Jeanie Bourke - Re: Fwd: Re: 89 Pleasant Ave., PI - Permit #2014-016723

1. The files for the plans must be submitted in PDF format.
2. It appears there is a new bathroom on the 2nd floor, is this part of the work for this application? This is not on the project description. The original permit was for a first floor remodel.

1. Floor framing details for the new opening for the spiral stair
2. A second floor plan showing how the space will be occupied, ie. bedrooms, living area, etc. If bedrooms, provide egress window specifications.
3. A section of the house showing the second floor ceiling height.
4. An electrical plan for the 2nd floor including smoke/co detectors and wiring

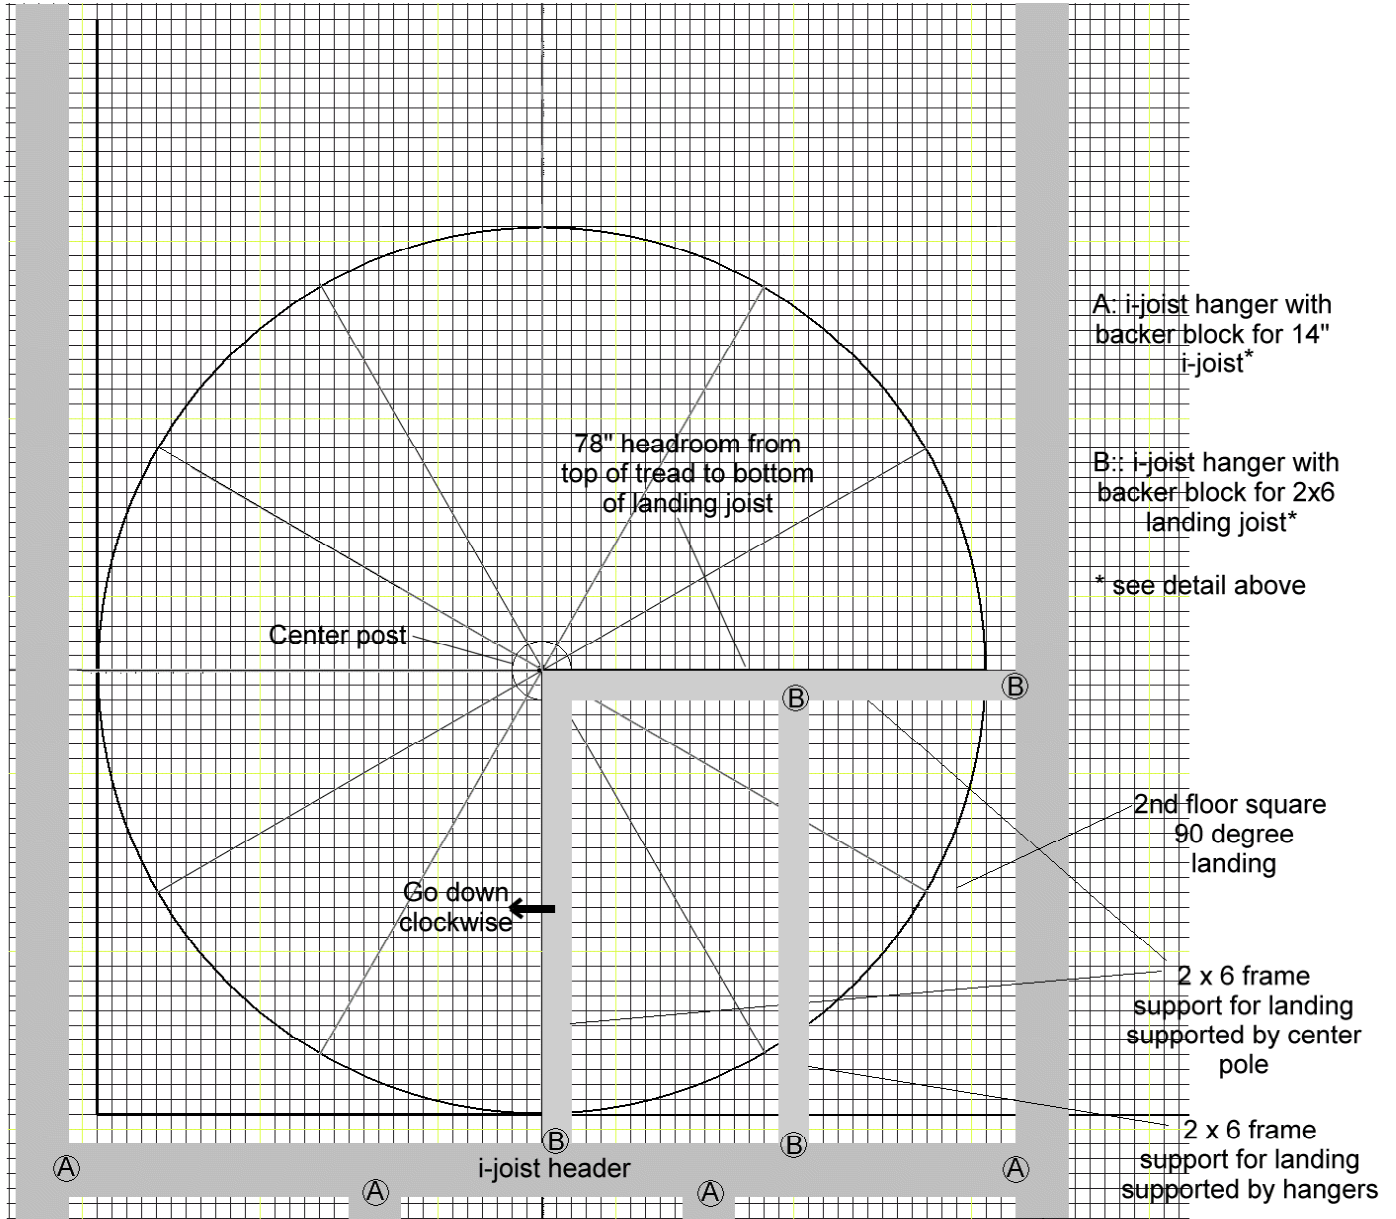
3. The "existing" exterior stairs to the 2nd floor is not shown on any previous plans or the site plan. Please include this on the site plan and when it was built.
4. Floor framing plans and location of the for the new opening for the spiral stair.
5. Provide an existing 2nd floor plan that indicates removal of the kitchen.
